COMMENTS

The proposals are for the AMENDED PROPOSAL Outline planning application for a hybrid application for demolition of existing hostel, development of a four storey 100 bed YMCA Hostel (All details submitted for determination) and a 2,3 and 4 storey building providing up to 43 residential apartments (All details retained for future determination as reserved matters, except means of access) with associated car parking and landscaping.

SWEPT PATH ANALYSIS
OF A 12M REFUSE VEHICLE

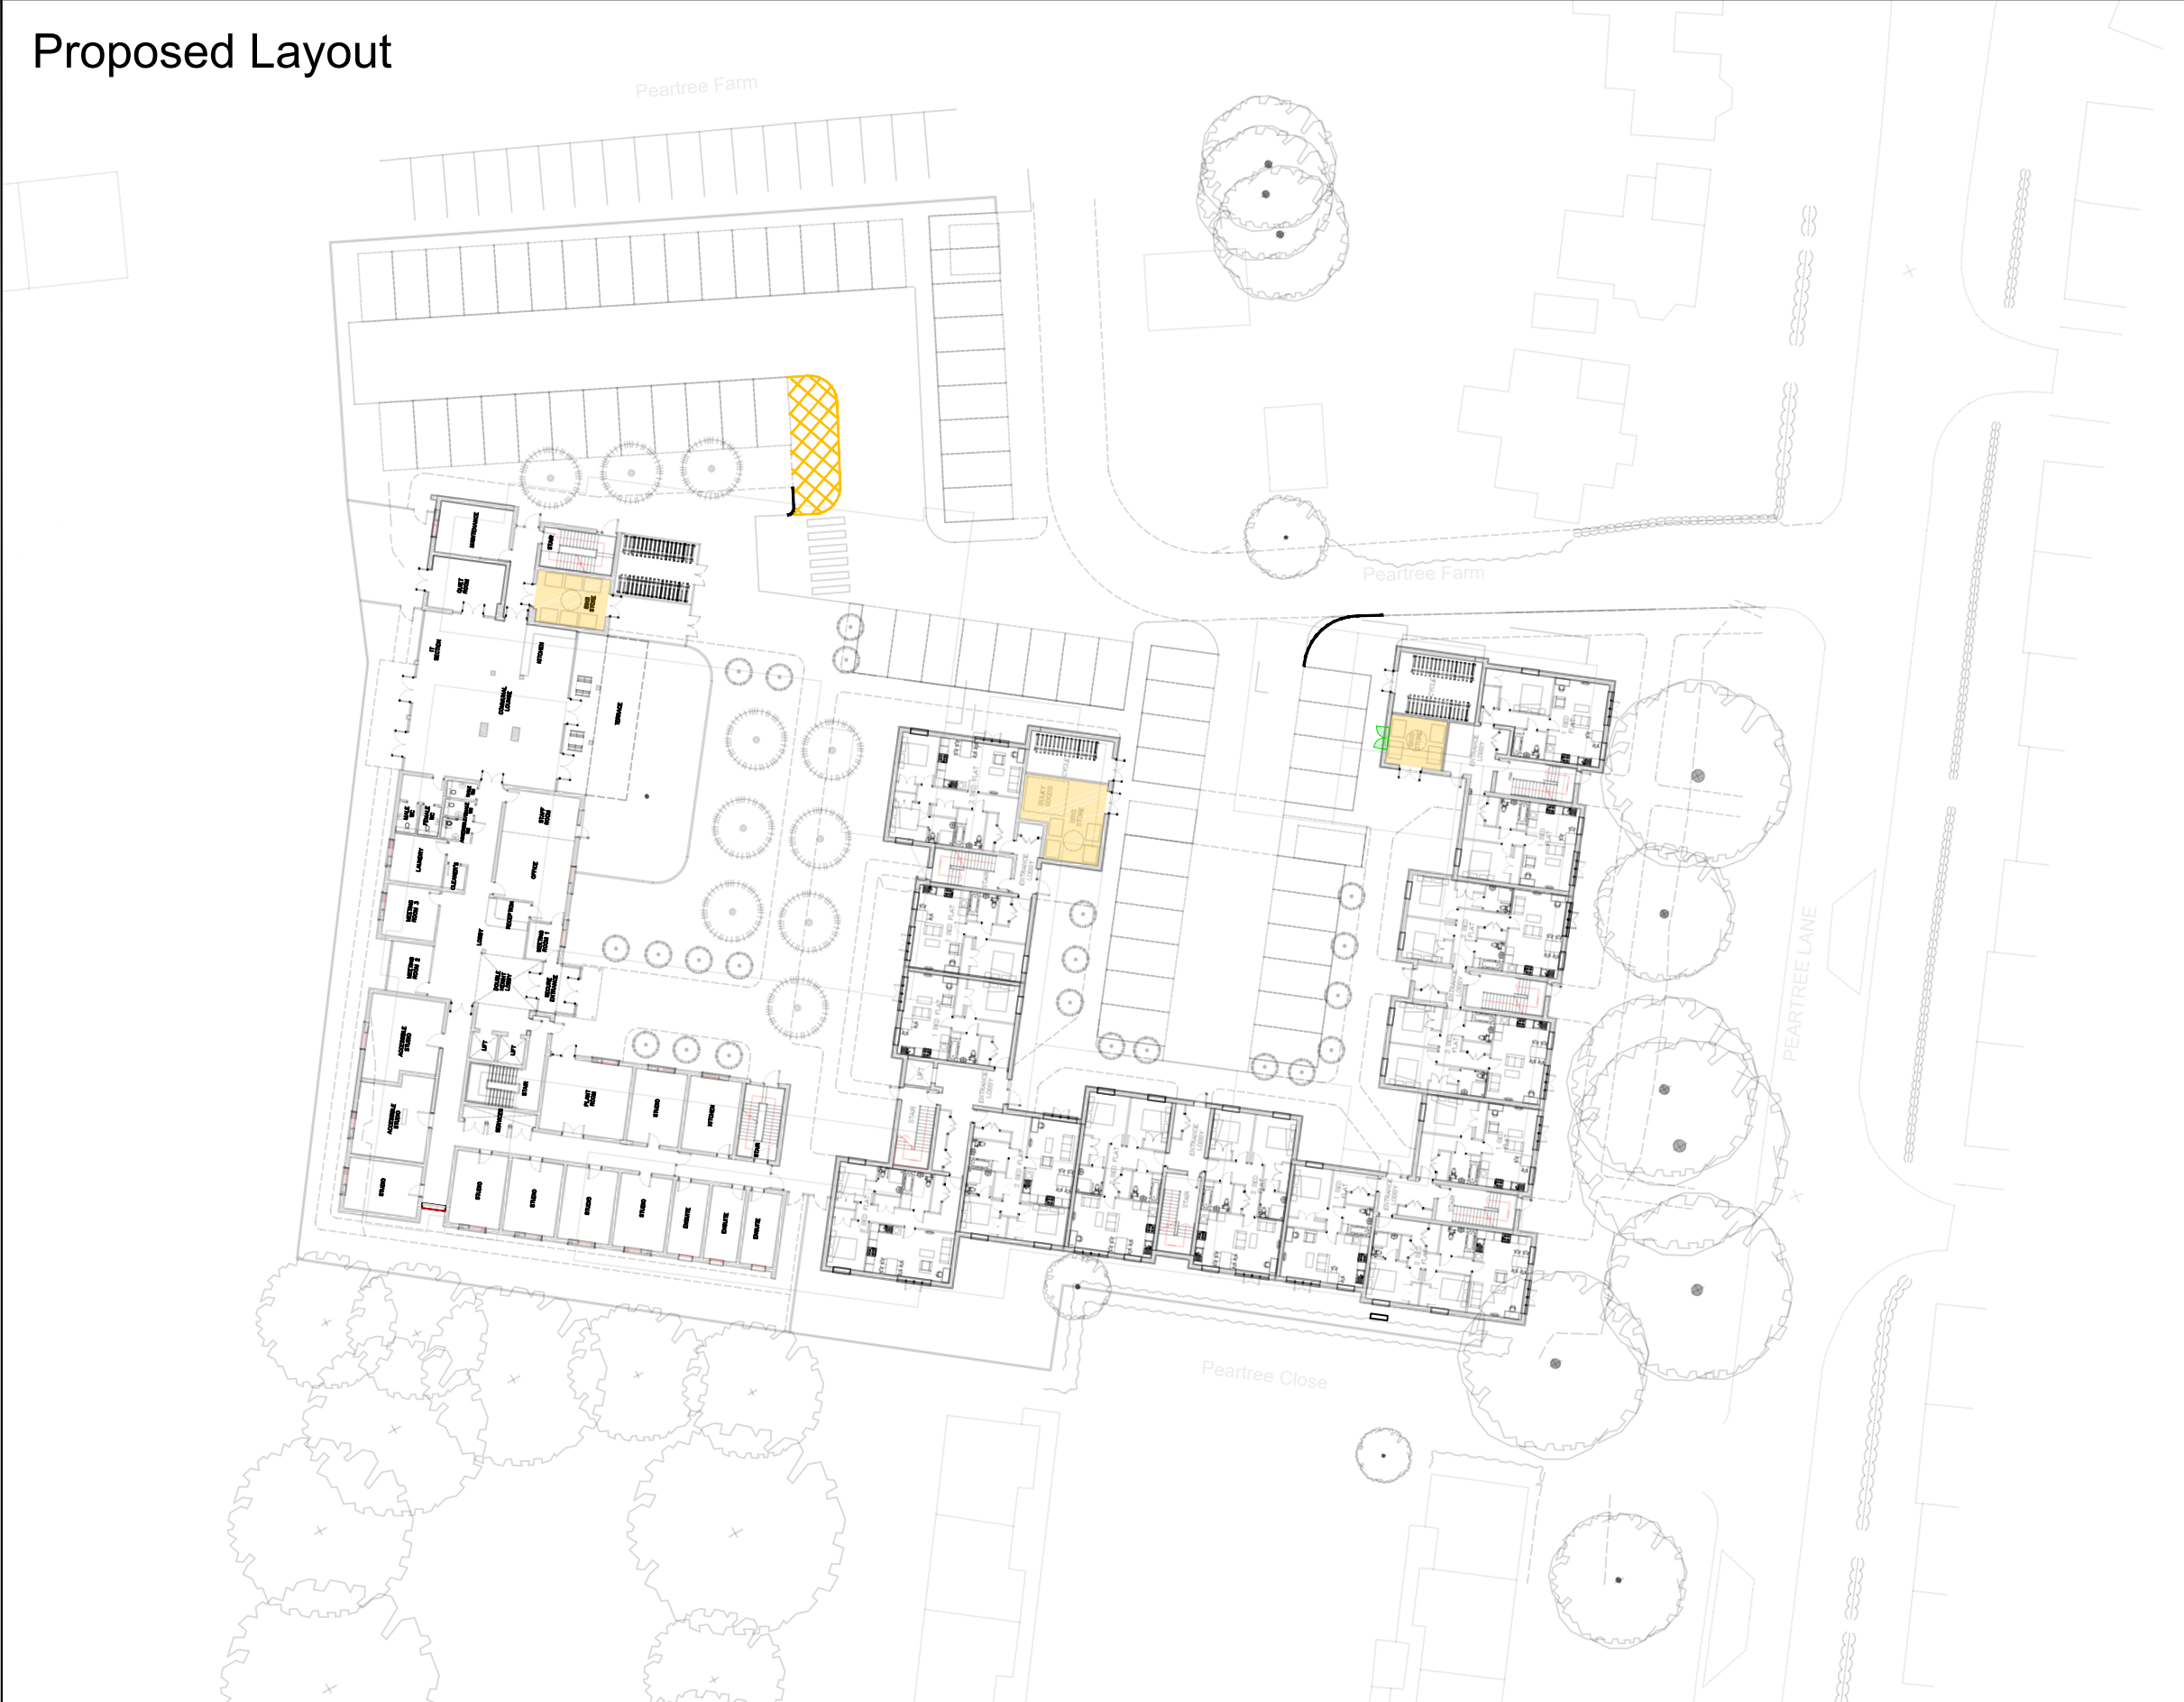
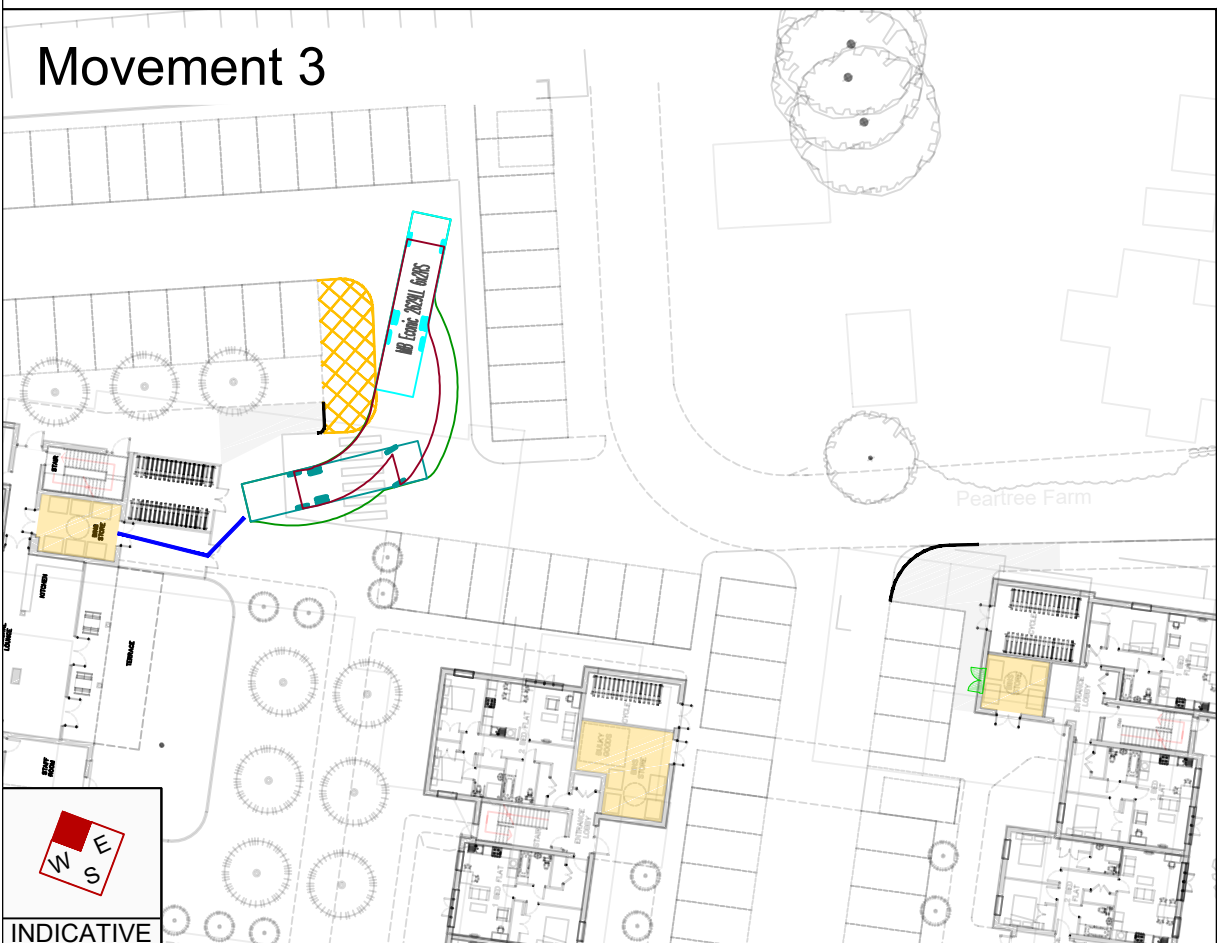
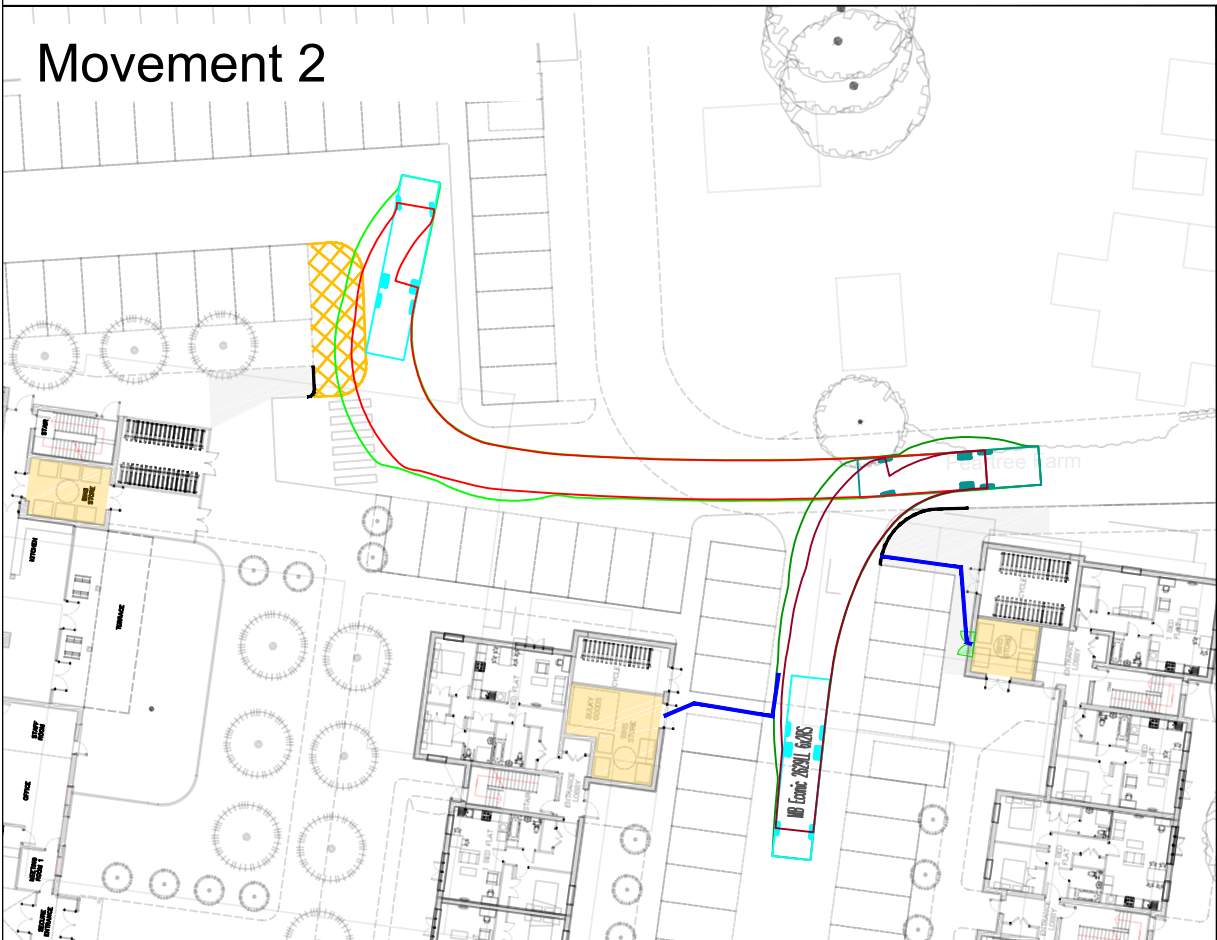
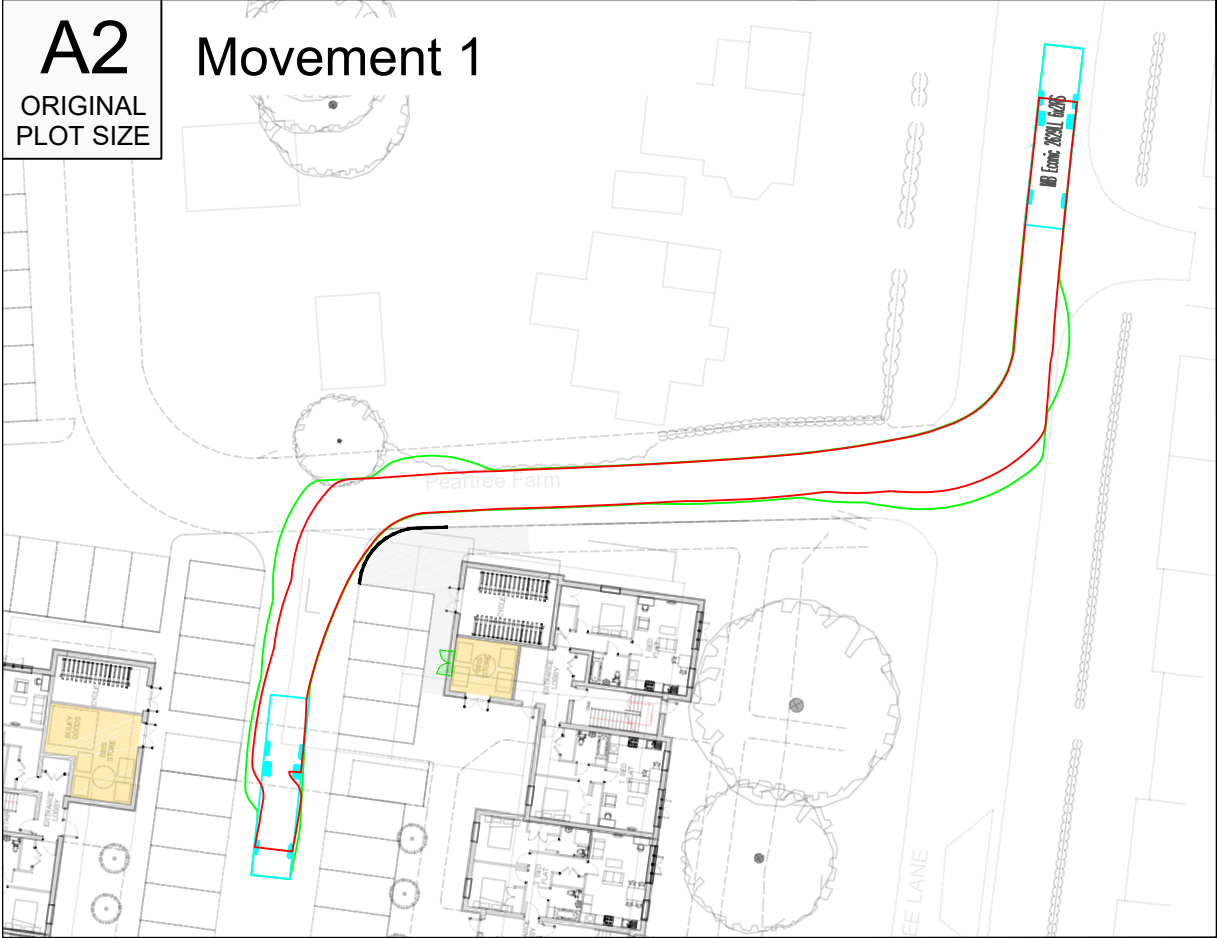
This is an amended application for the swept path analysis for refuse vehicles. Drawing SP07 demonstrates a vehicle length of 12.1m. Although this is under the required length (12.205m) I accept that there is enough room demonstrated on the plan to allow for a vehicle of the 12.205m to manoeuvre appropriately. Therefore, the Highway Authority would not wish to restrict the grant of planning permission
